OXFORDSHIRE COUNTY COUNCIL'S RESPONSE TO CONSULTATION ON THE FOLLOWING DEVELOPMENT PROPOSAL

Application no: 22/00747/OUT

Proposal: Outline planning application for the development of up to 370 homes, public open space (including play areas and woodland planting), sports pitches and pavilion, drainage and engineering works, with all matters reserved (appearance, landscaping, layout and scale) except for vehicular and emergency accesses to Bicester Road.

Response Date: 07/12/2022

Access Strategy

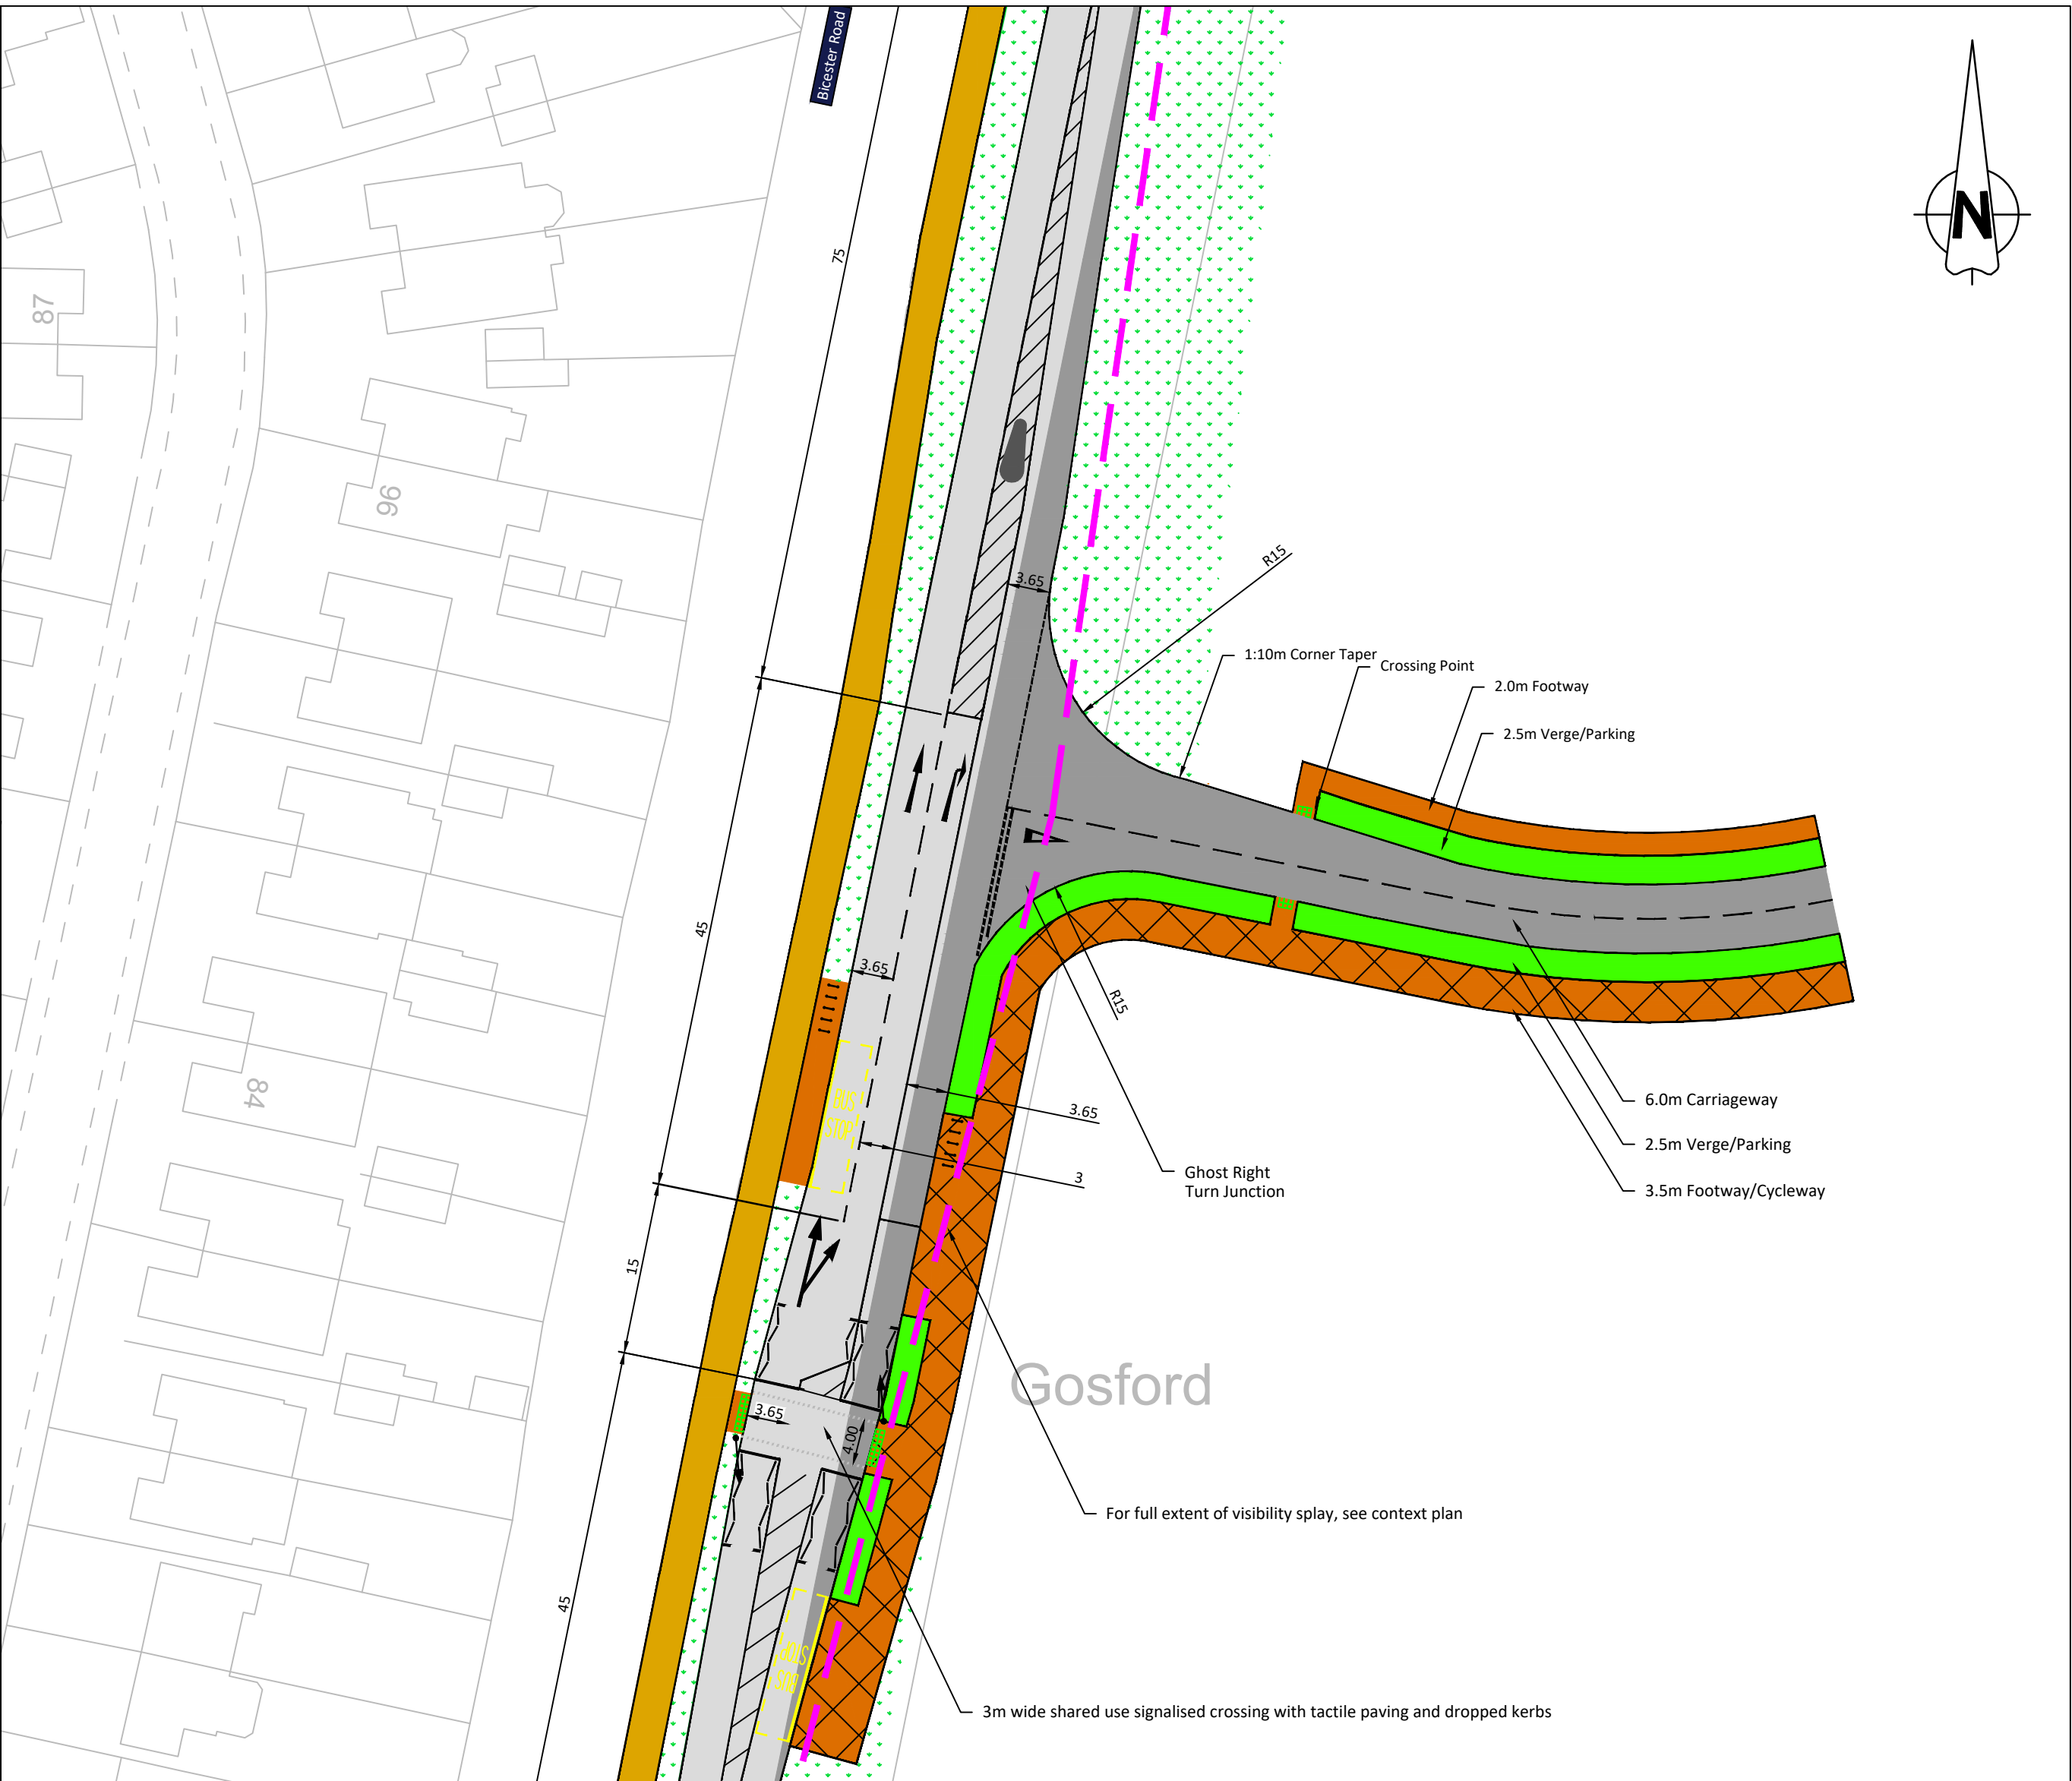
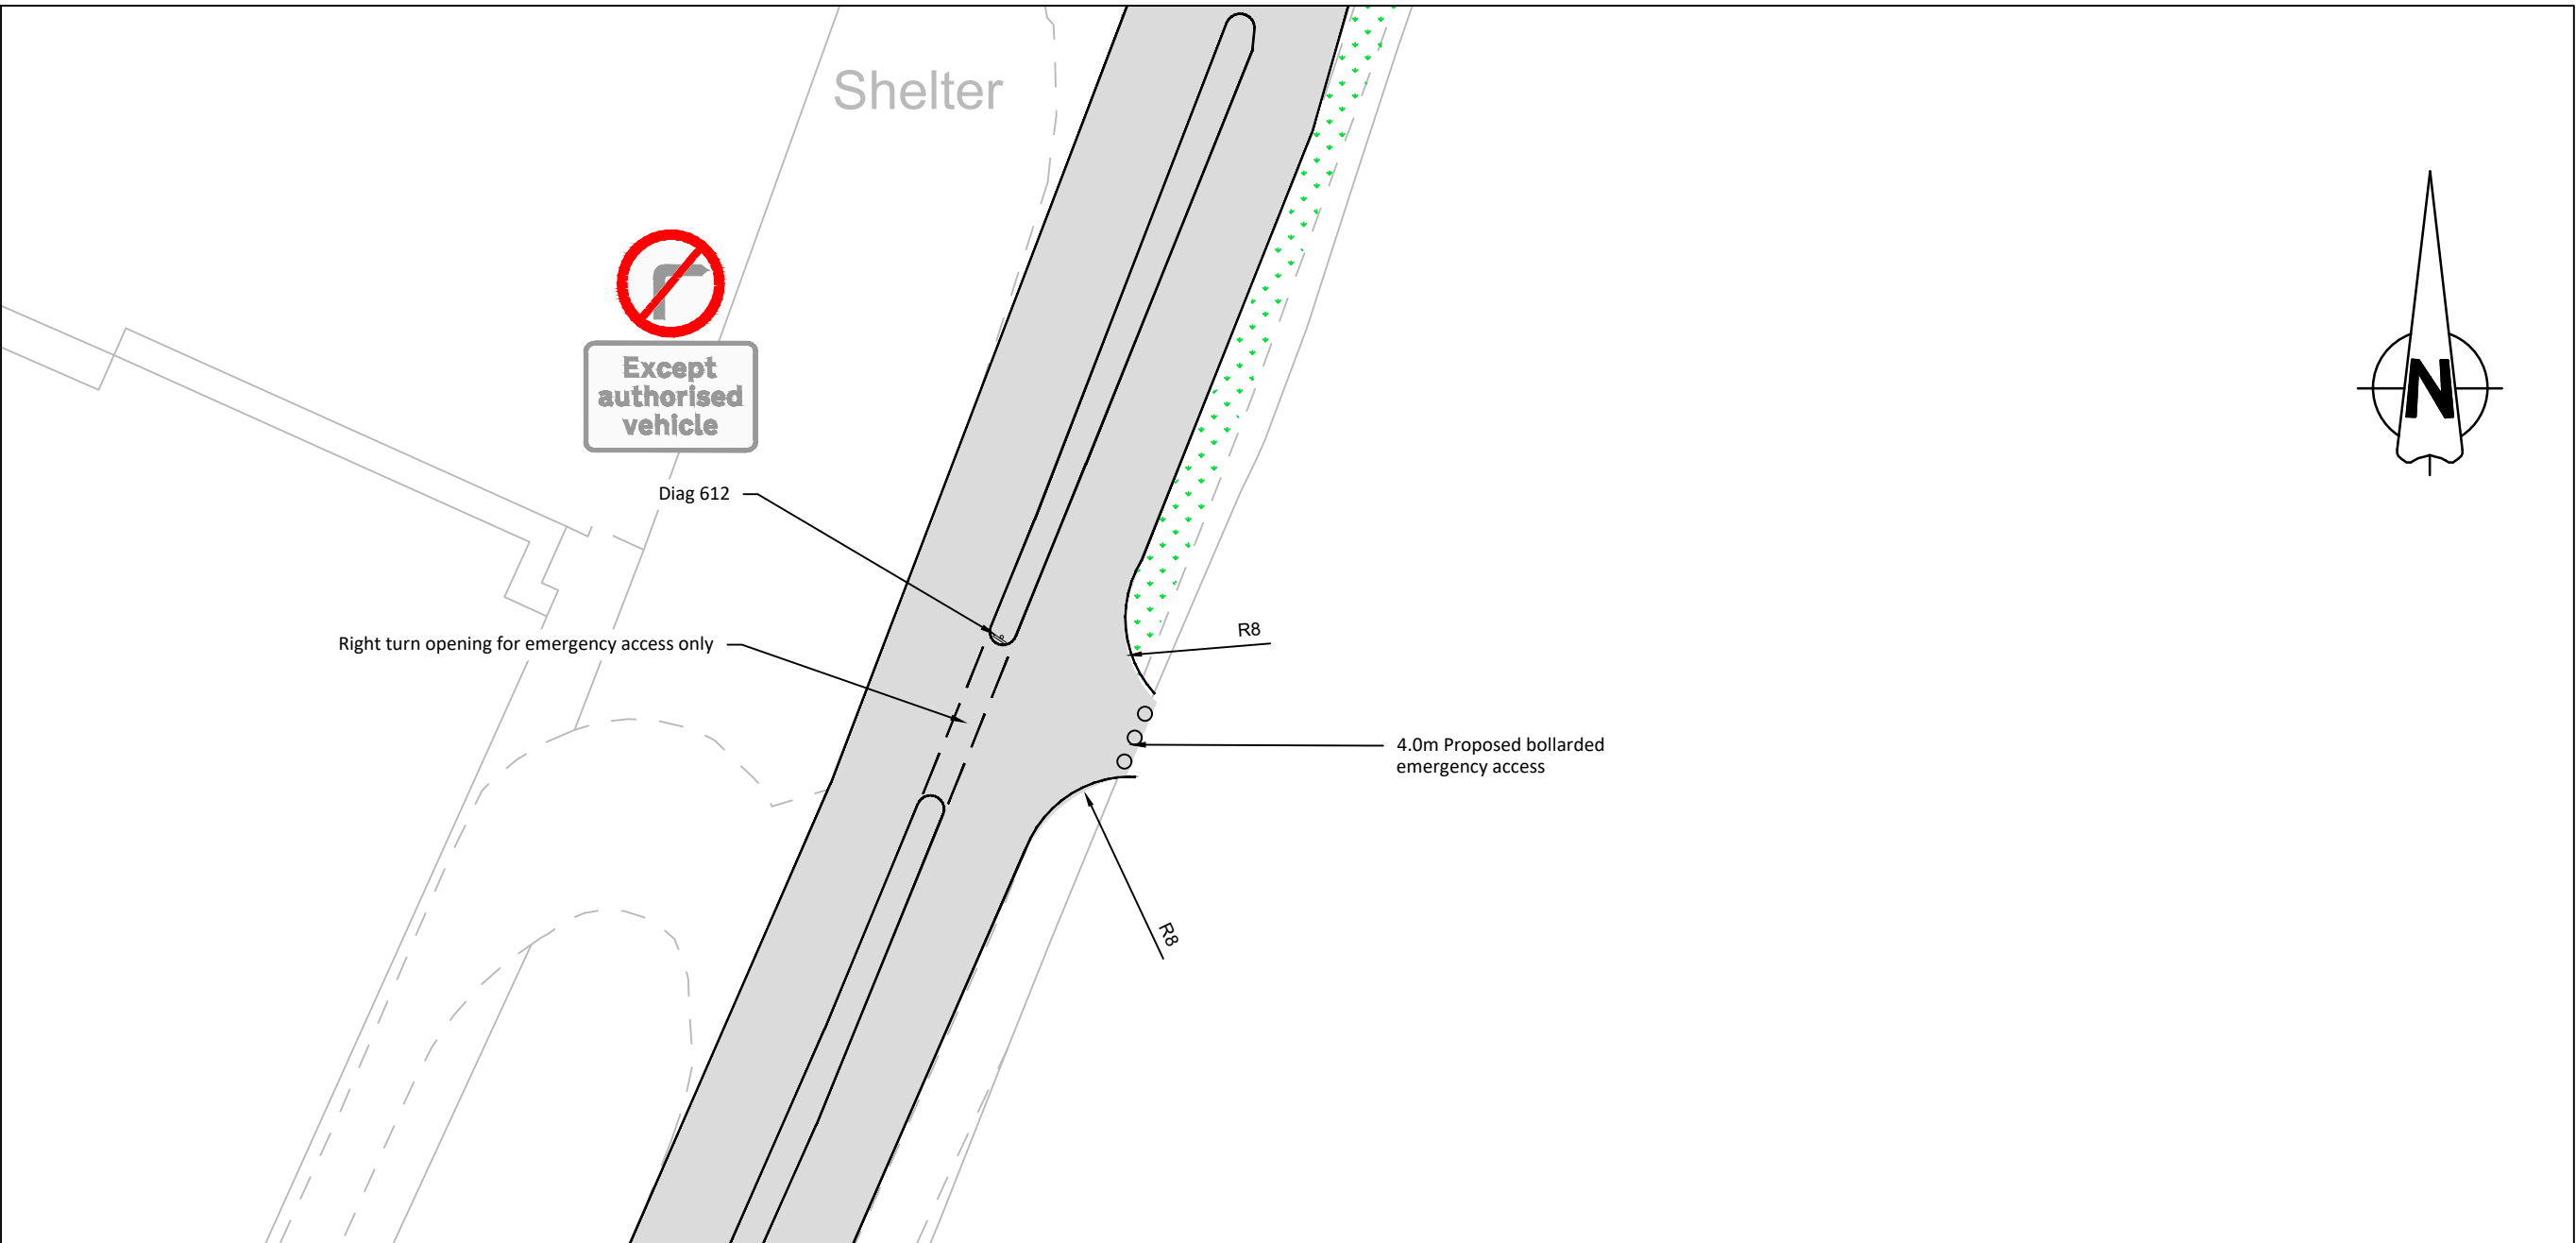
However, OCC wish to make note of some changes that have been made to the Development Framework Plan and these shall be considered as part of the overall access strategy. These are;

- 2x New bus stops indicated along Bicester Road adjacent to the Hill Development parcel.
- Relocation of the proposed allotments to the south of the development.
- The extension of the combined cycleway/ footway to the Kidlington roundabout.
